<b>Application Ref:</b>	3/2025/0569			 <div>Ribble Valley Borough Council</div> <hr/> <div><a href="http://www.ribblevalley.gov.uk">www.ribblevalley.gov.uk</a></div>
<b>Date Inspected:</b>	25/09/2025	<b>Site Notice:</b>	25/09/2025	
<b>Officer:</b>	MC			
<b>DELEGATED ITEM FILE REPORT:</b>				<b>REFUSAL</b>

<b>Development Description:</b>	Proposed demolition of redundant barn and erection of farm worker's (self-build) dwelling to include new vehicular track.
<b>Site Address/Location:</b>	Wood Top Farm Chipping Road Chaigley PR3 2TS

PROPOSED NORTH WEST ELEVATION  
Scale 1:100

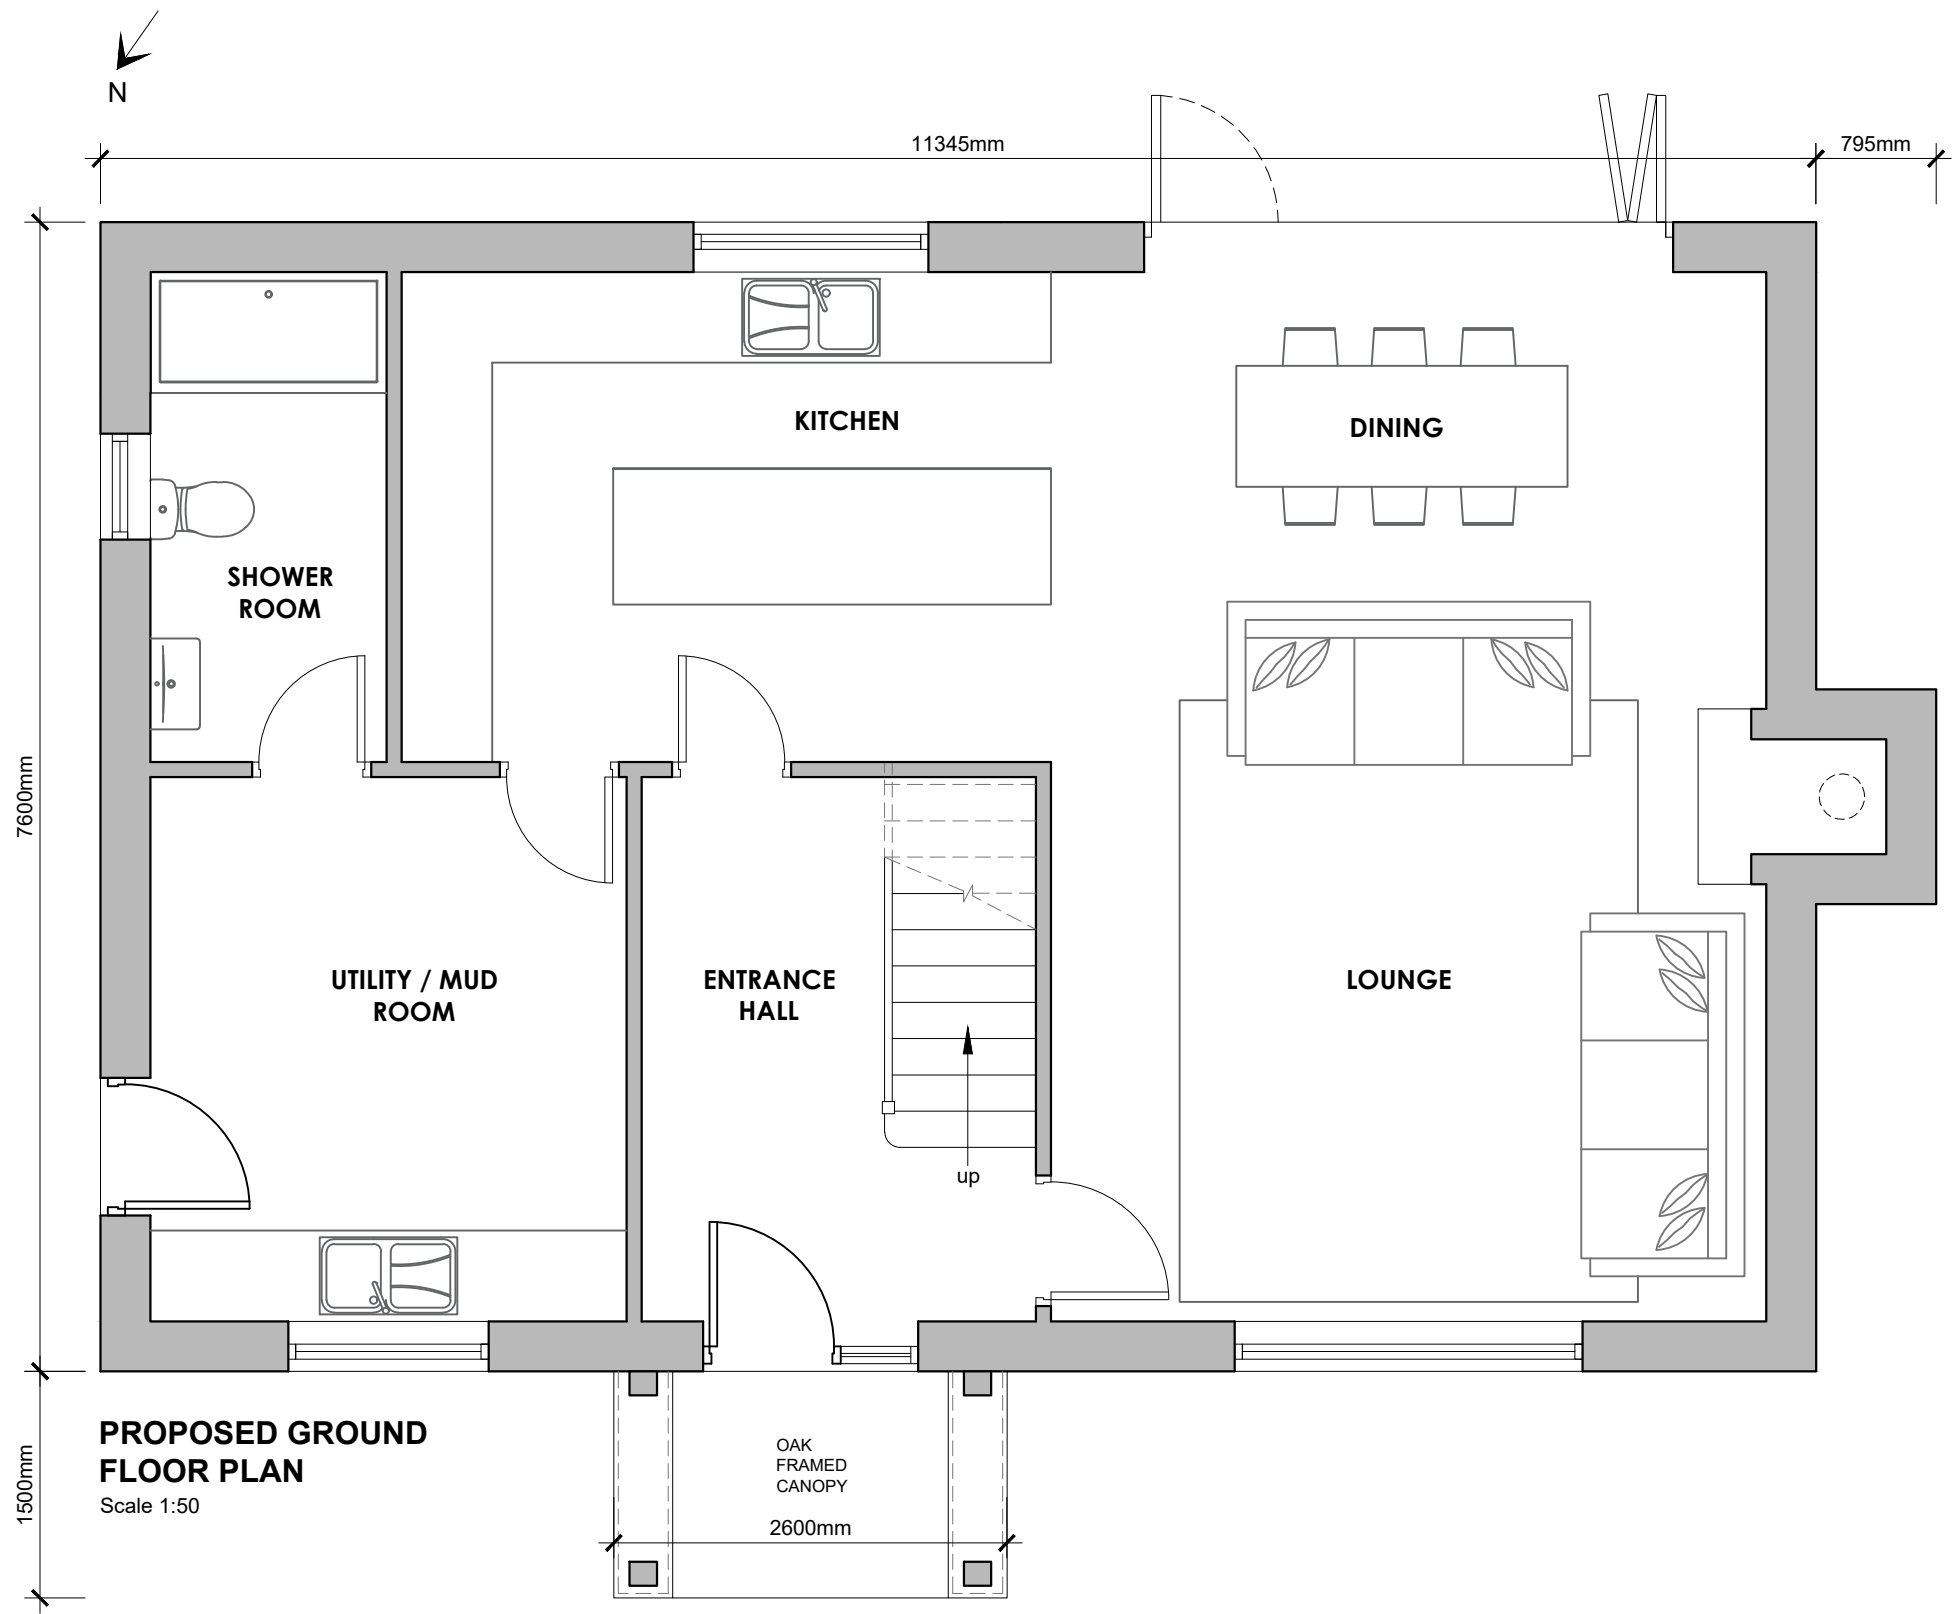
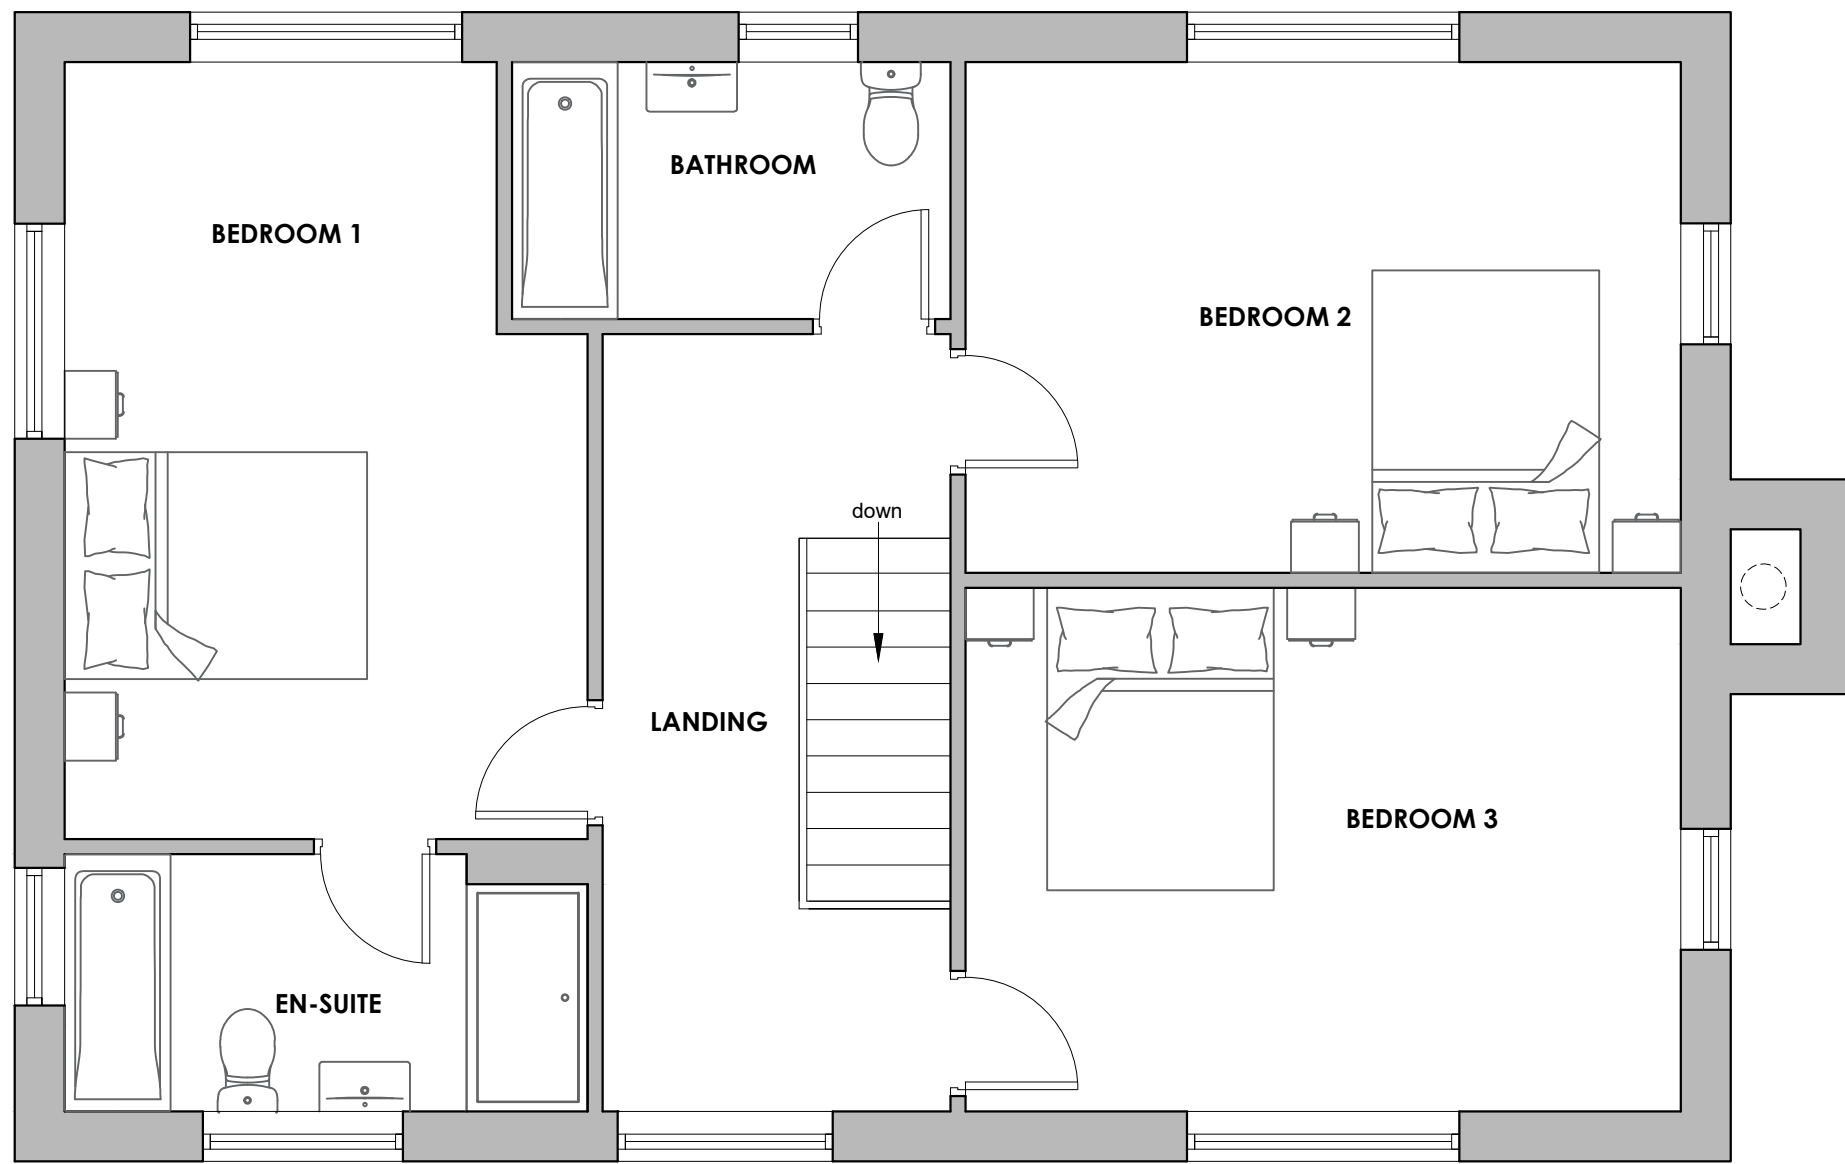
The Council consider that there are improvements in terms of design, with the introduction of traditional stonework to all elevations and a more simplistic fenestration pattern with simple glazing and stone surrounds. Notwithstanding this, the location of the building has not been amended from the refused scheme and the overall size and scale of the dwelling is still considered to be significantly larger than the dilapidated barn. As with the previously refused scheme, the dwelling would be sited on the opposite side of the road to the farm buildings and existing agricultural worker dwellings, in a prominent position within the street scene and within the Forest of Bowland National Landscape. The introduction of a dwelling with residential curtilage and domestic paraphernalia associated with the dwelling, together with a considerable length of gravel track serving the dwelling, to this side of the road is considered to be out of keeping with the pattern of development and would be located in a prominent position within the street scene and would result in a harmful intrusion into the Forest of Bowland National Landscape that would detract from the visual and landscape character of the area. As such, the previous reason for refusal has not been overcome and the scheme would fail to comply with Key Statement EN2 and Policies DMG2, DME2, DMH3 and DMG1.

DATUM 113.00
PROPOSED SITE SECTION A - A
Scale 1:100

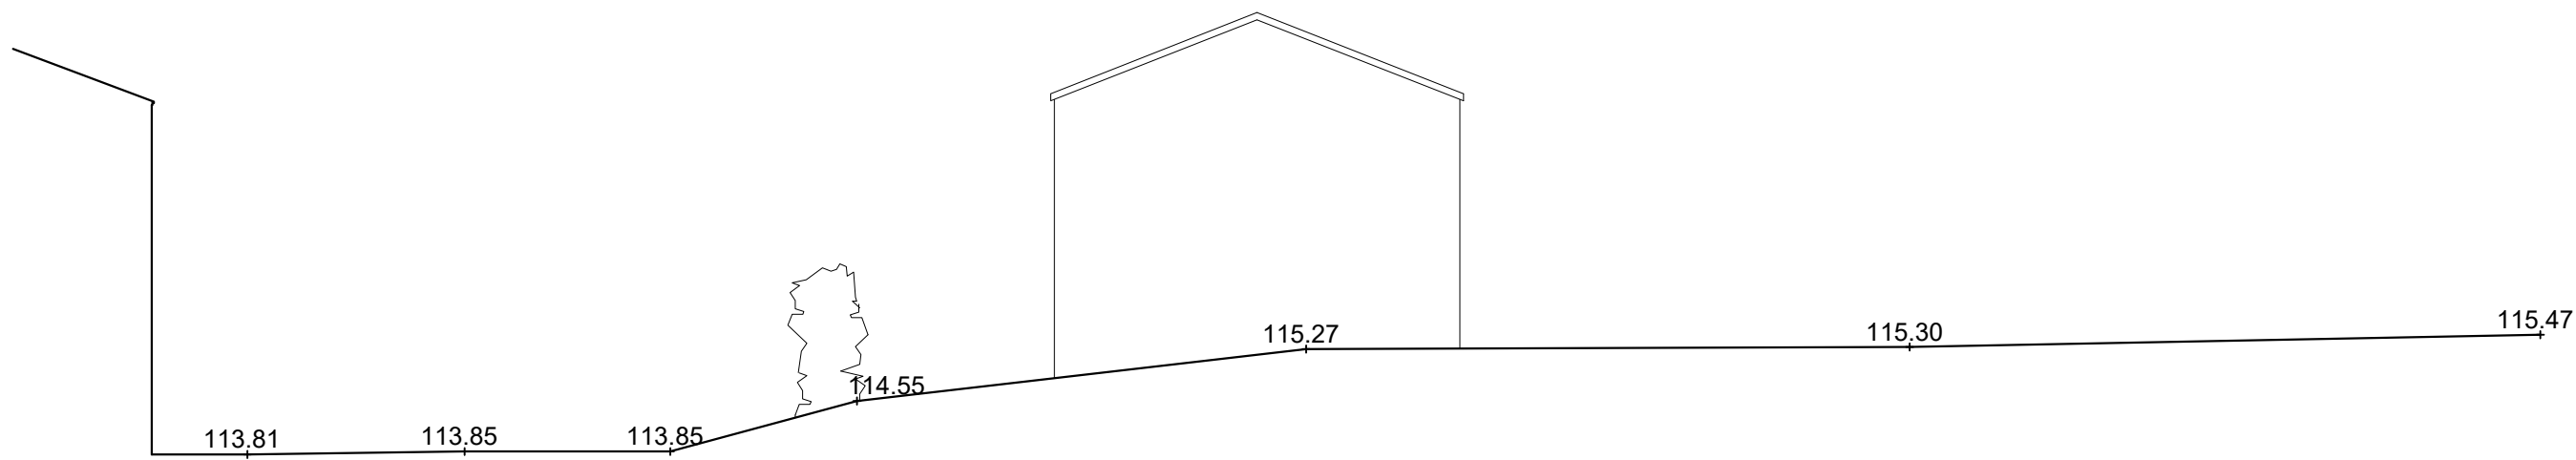
The delegated report for the refused scheme also considered the dwelling to be substantially larger both in footprint and in height than the barn to be demolished and considered that the dwelling would result in a significantly greater intrusion into the Forest of Bowland National Landscape, given its siting with no other built development and directly obstructive of the landscape which includes sights of Longridge Fell.
